EL PASO COUNTY GRADING AND EROSION CONTROL PLAN CHECKLIST

EPC Project Number:

GEC DETAILS

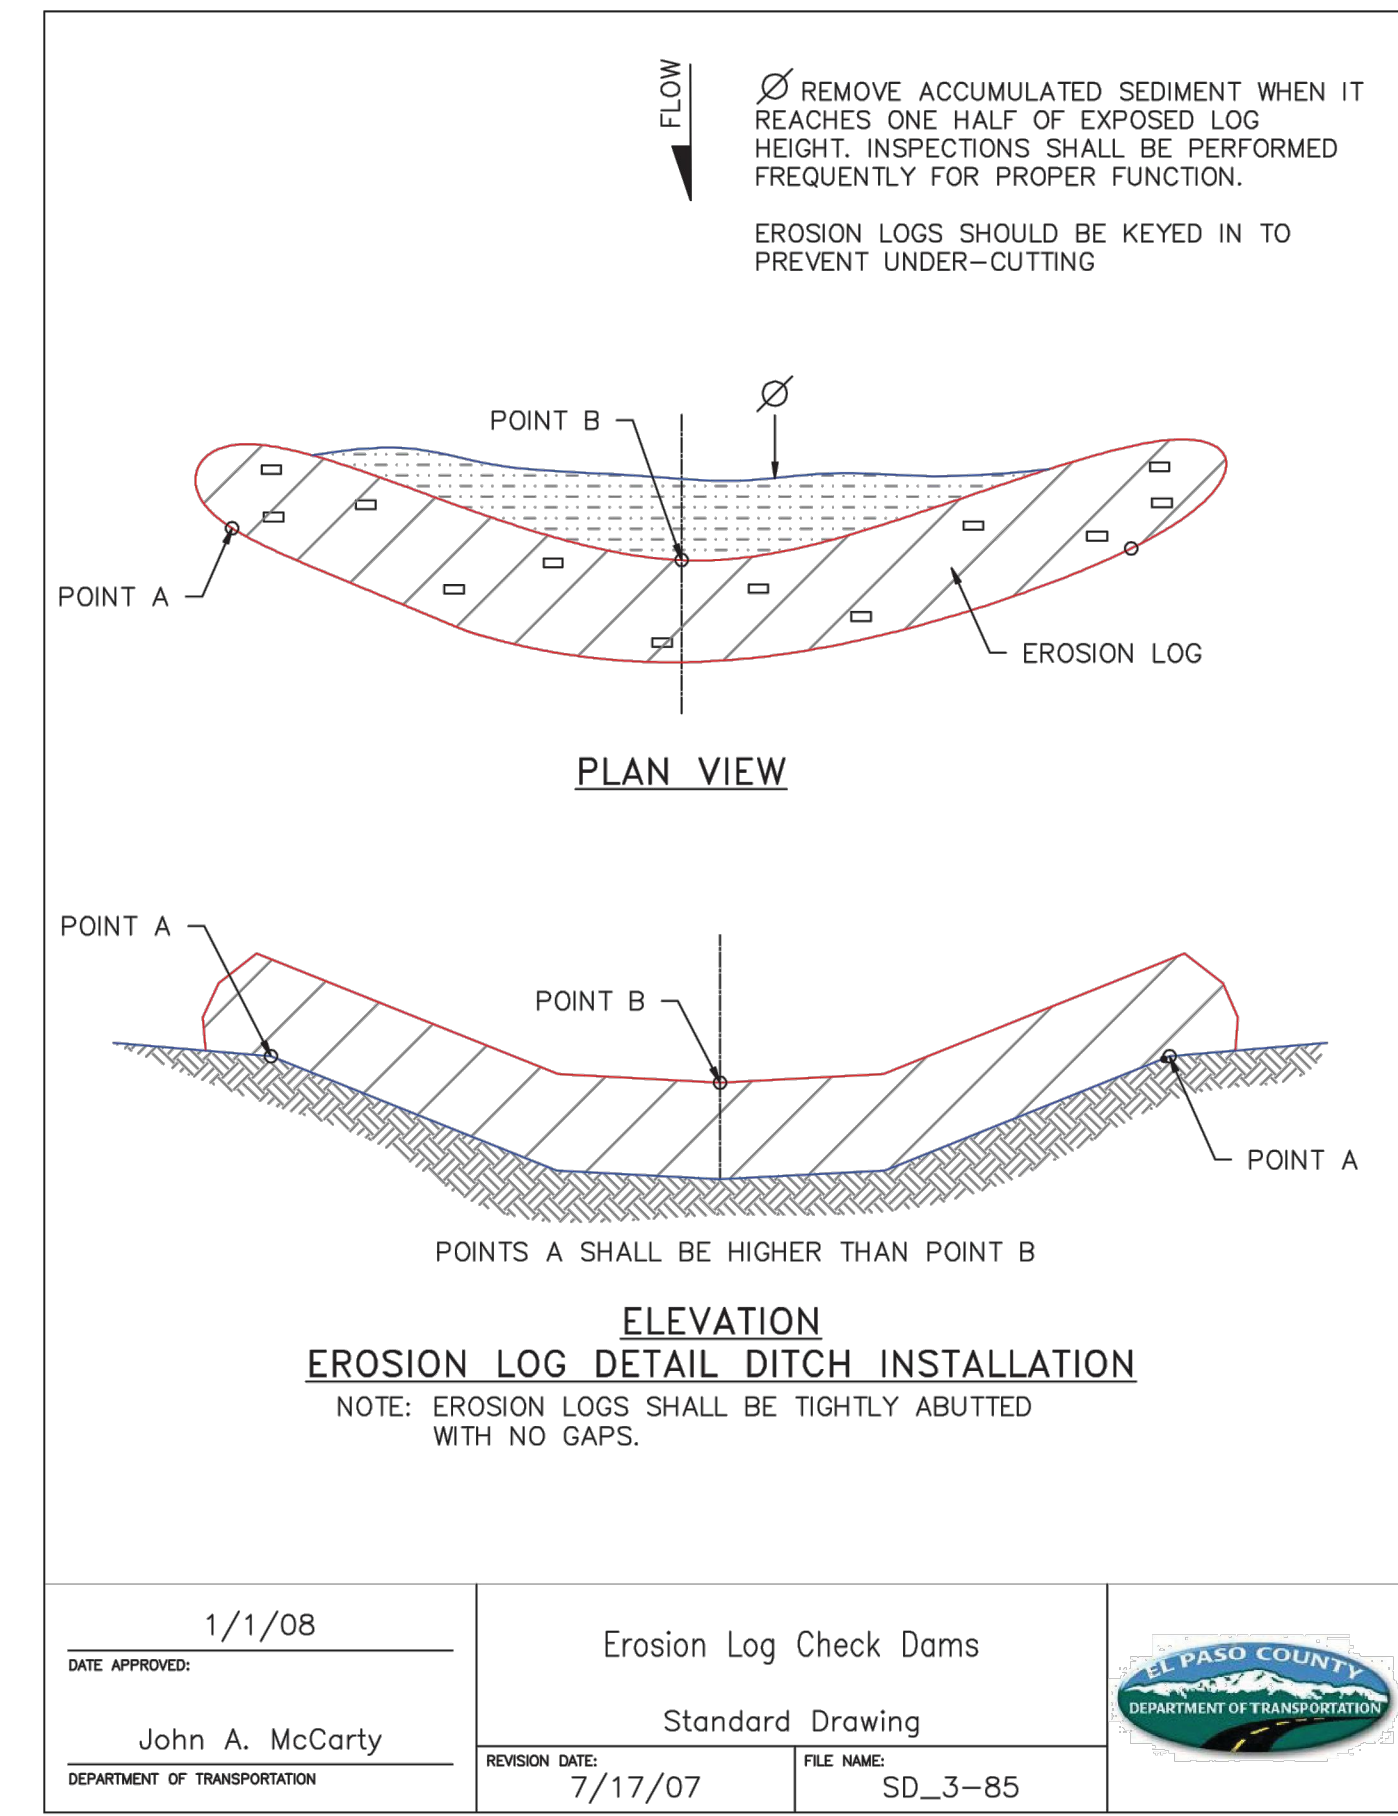
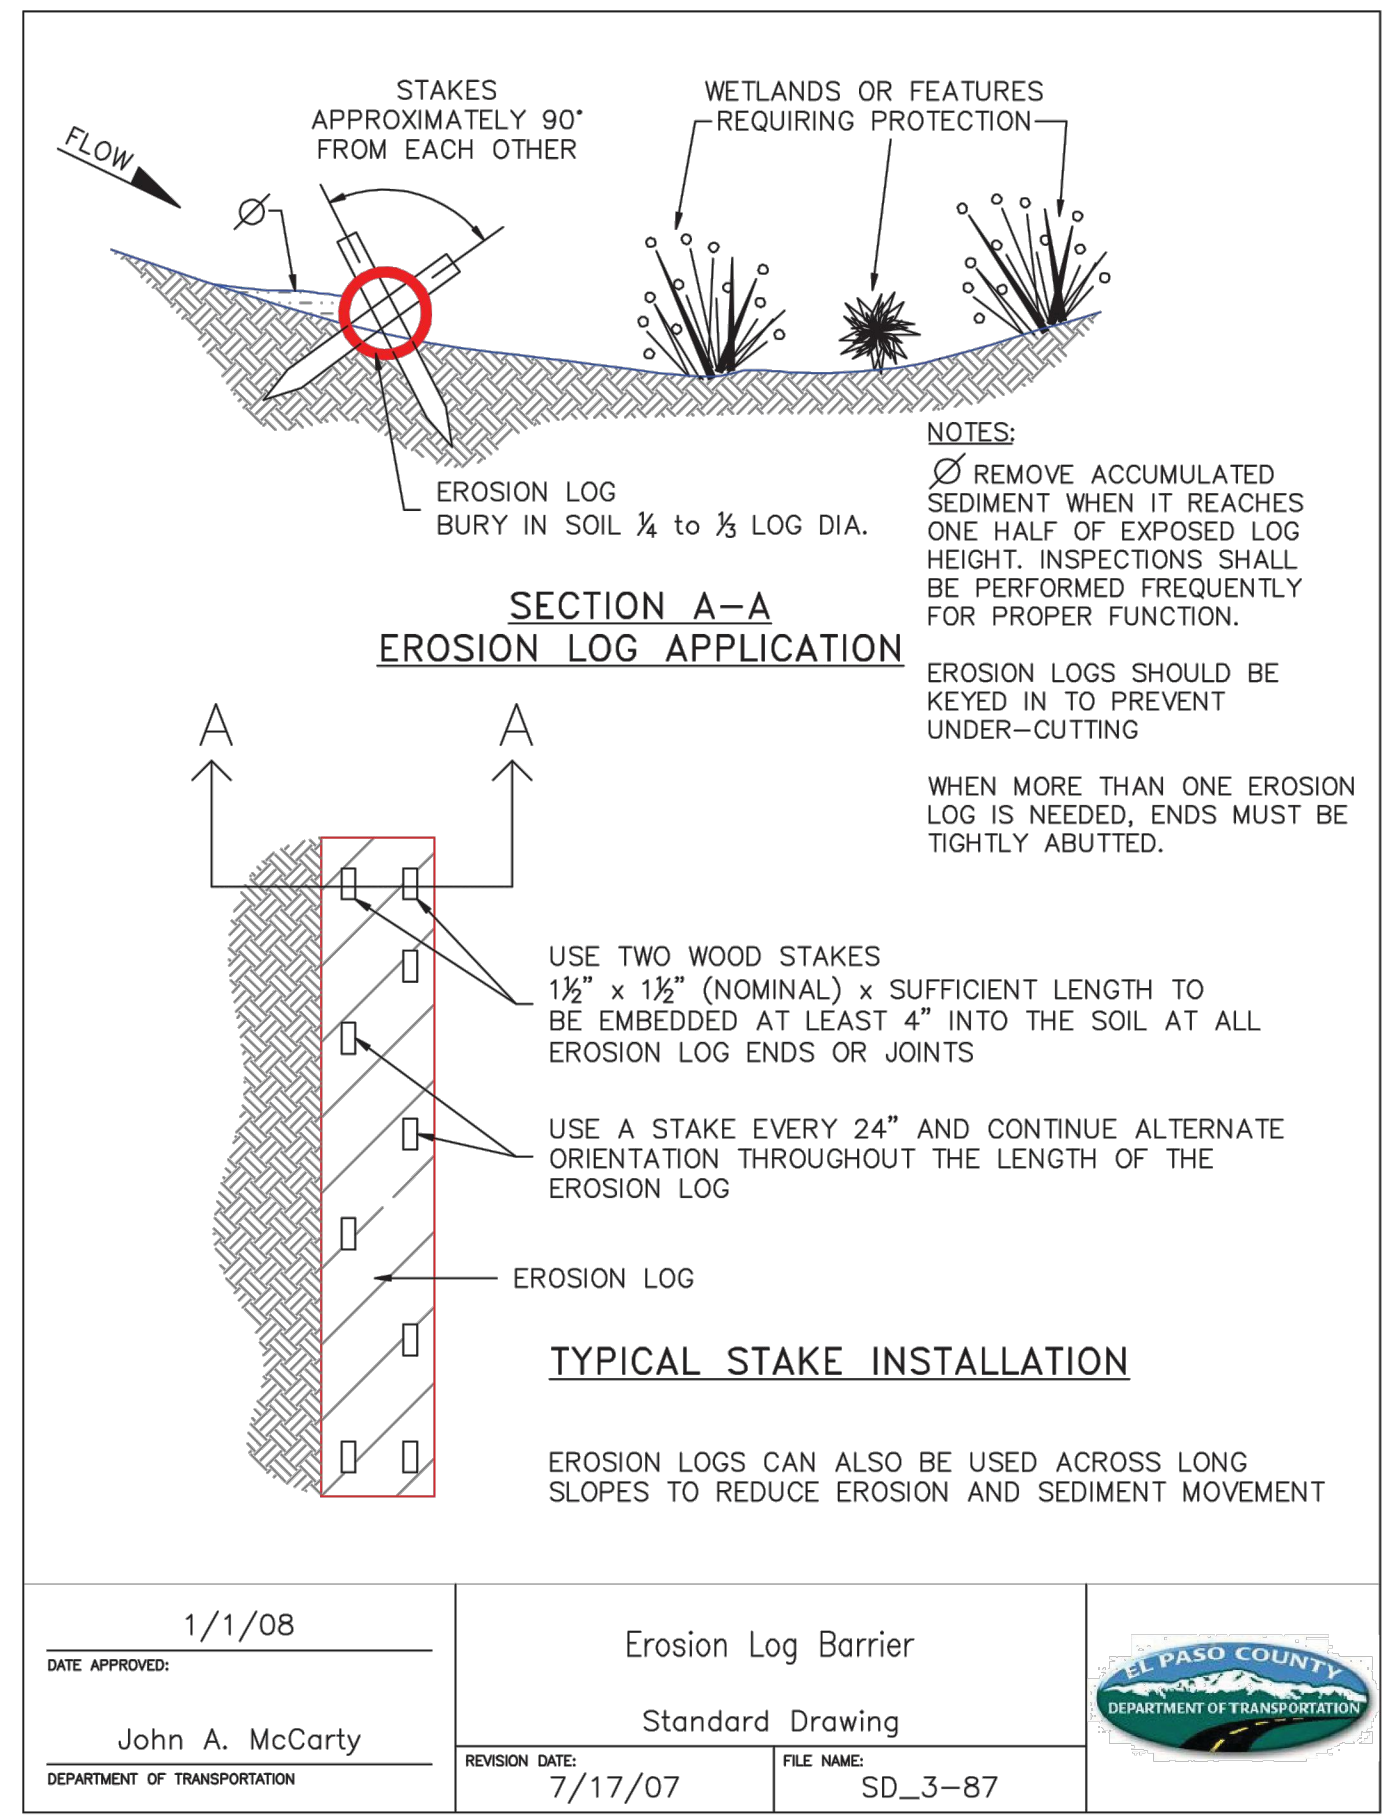
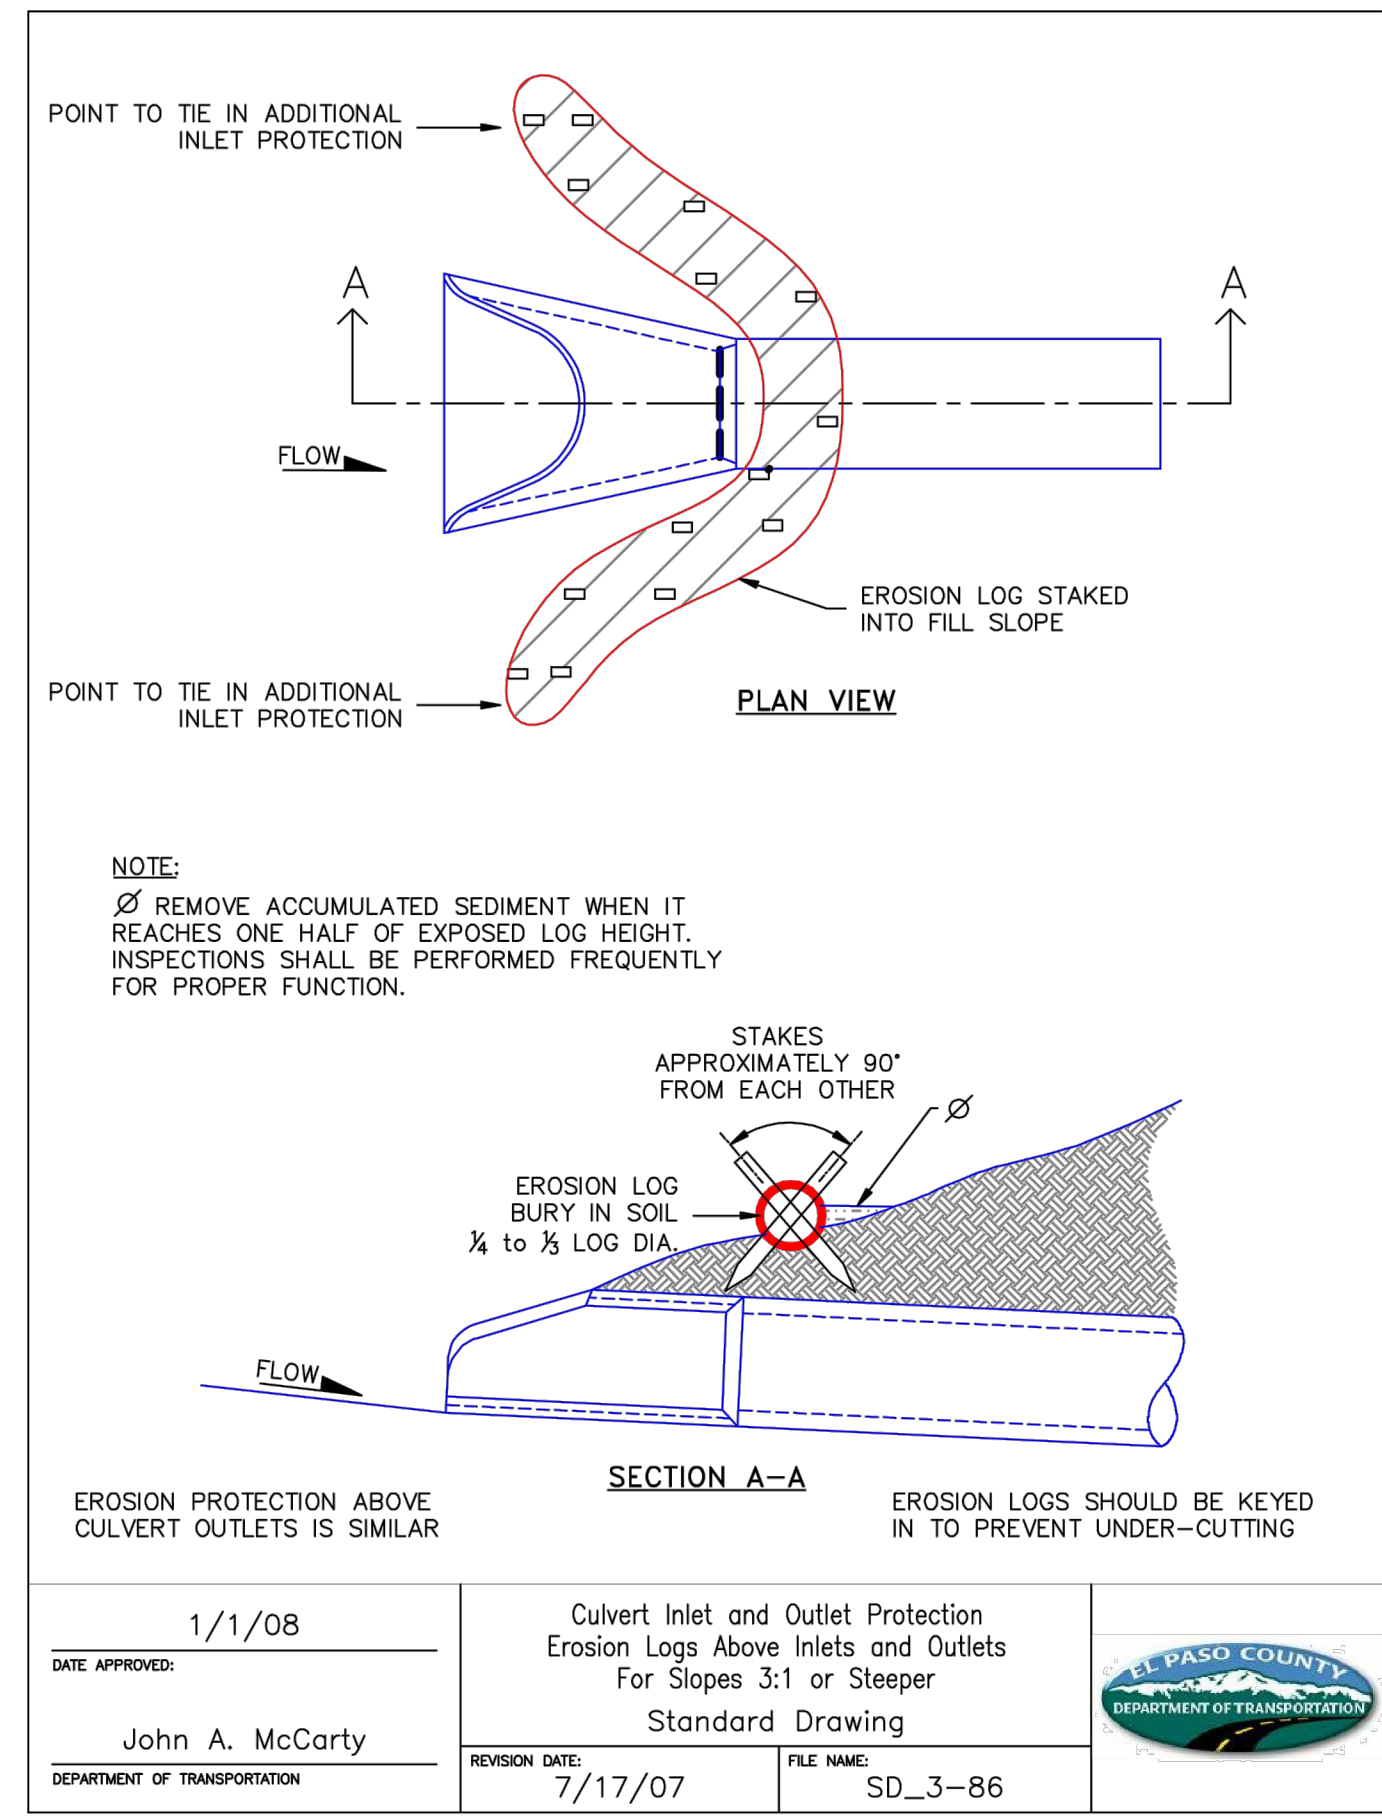
Applicant	EPC
y	Dewatering operations to include locations of diversion, pump and discharge(s) as anticipated at time of design NO DEWATERING OPERATIONS ANTICIPATED		N/A
z	All proposed temporary construction control measure details. Custom or other jurisdiction's details used must meet or exceed EPC standards		N
aa	Any off-site stormwater control measure proposed for use by the project and not under the direct control or ownership of the Owner or Operator NO OFF-SITE CONTROL MEASURE PROPOSED FOR USE		N/A
bb	Existing and proposed permanent storm water management facilities, including areas proposed for stormwater infiltration or subsurface detention		Y
cc	Existing and proposed easements (permanent and construction) including required off-site easements		Y
dd	Retaining walls shall not to be located in County ROW unless approved via license agreement. A building permit from Regional Building Department is required for walls greater than or equal to 4 feet in height, series of walls, or walls supporting a su NO RETAINING WALLS PROPOSED WITH THIS FILING		N/A
